CITY OF ALBUQUERQUE

Re: Manual Shops
7212 Manual Blvd 87110
60-Day Temporary Certificate of Occupancy
Transportation Development Final Inspection
Engineer's/Architect's Stamp dated 6-3-19 (H19D040)
Certification dated 7-27-20

REVISION DATE
DATE: 05-30-2019
SHEET NUMBER: AS-1.0

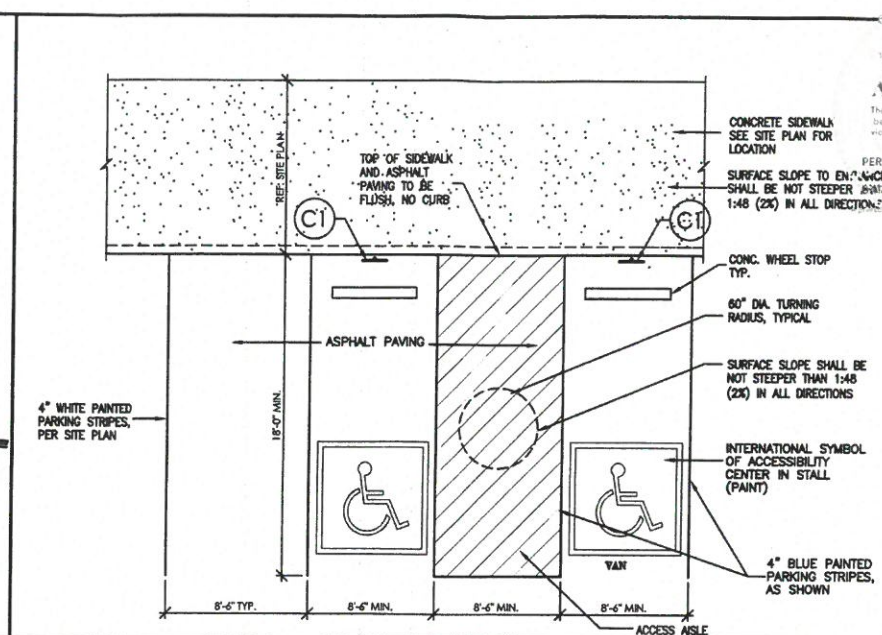
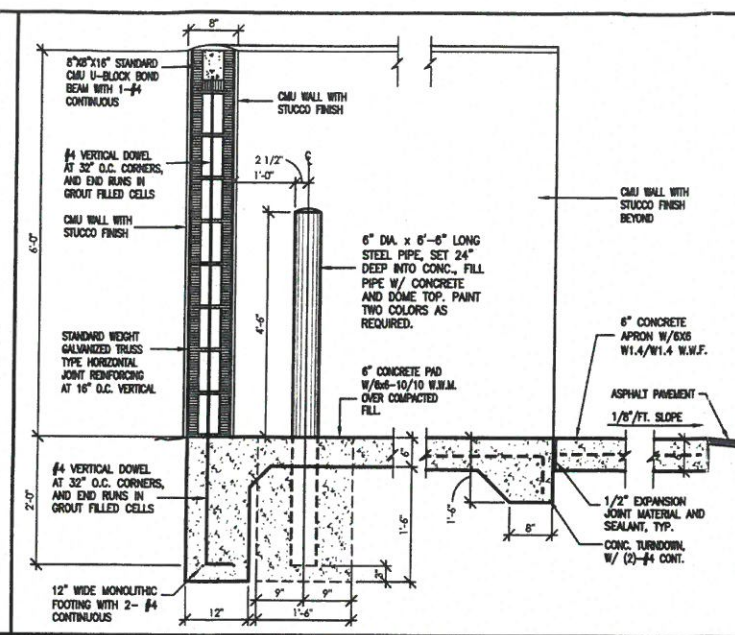
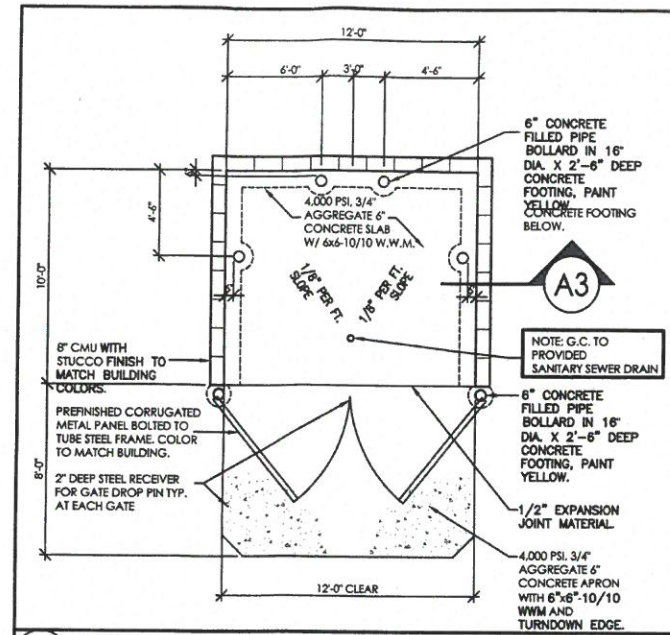
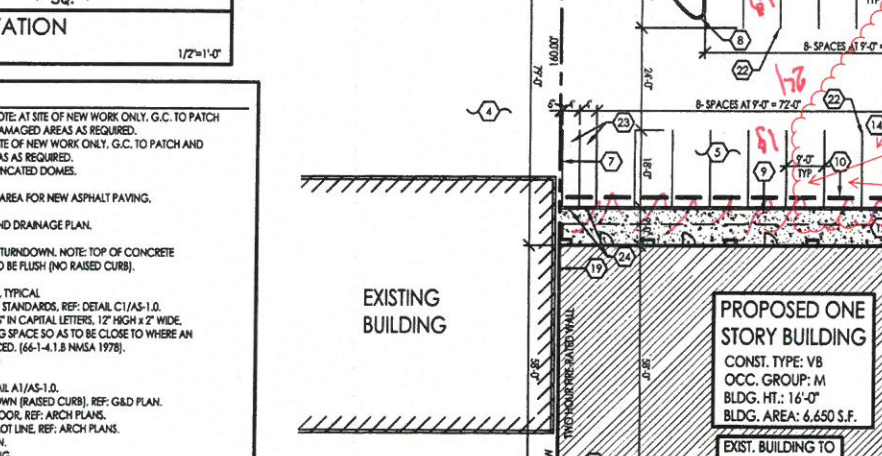
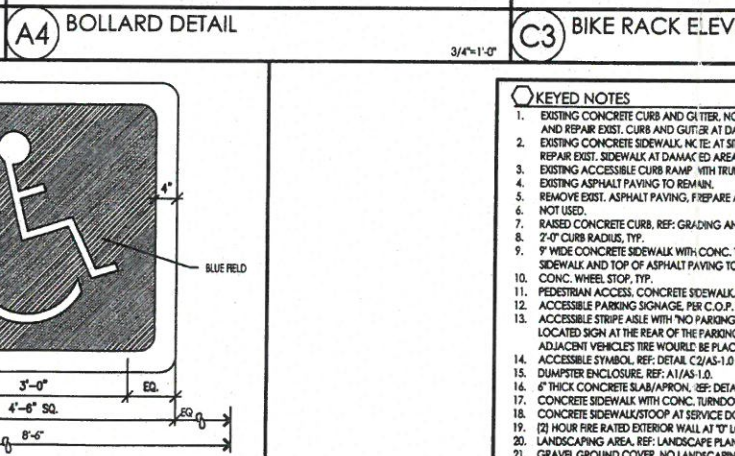
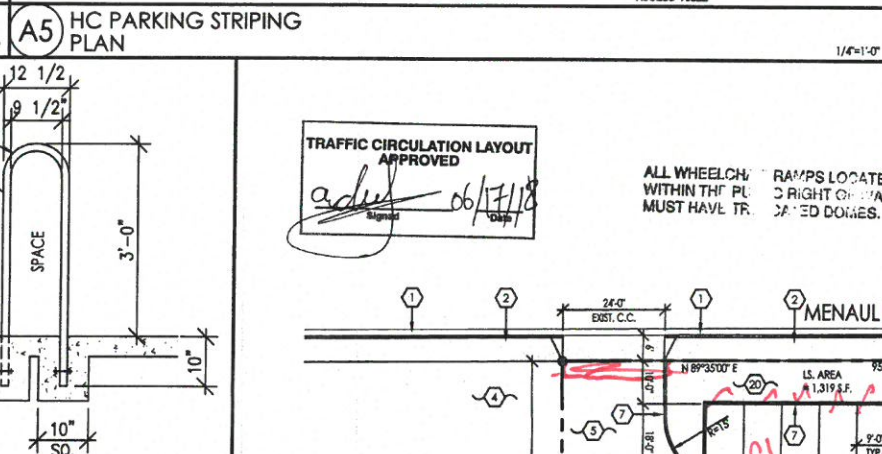
- Please cut back the wall as shown on the plan and label No Parking and label Compact stall.

We will cut the wall back and eliminate one parking space and convert one regular space into a small car space. The clear opening will not be less than 12'-0" from the existing bollards to the new bollard installed to protect the wall. There will be 12'-0" clear at all points north of the power pole (see attached drawing).
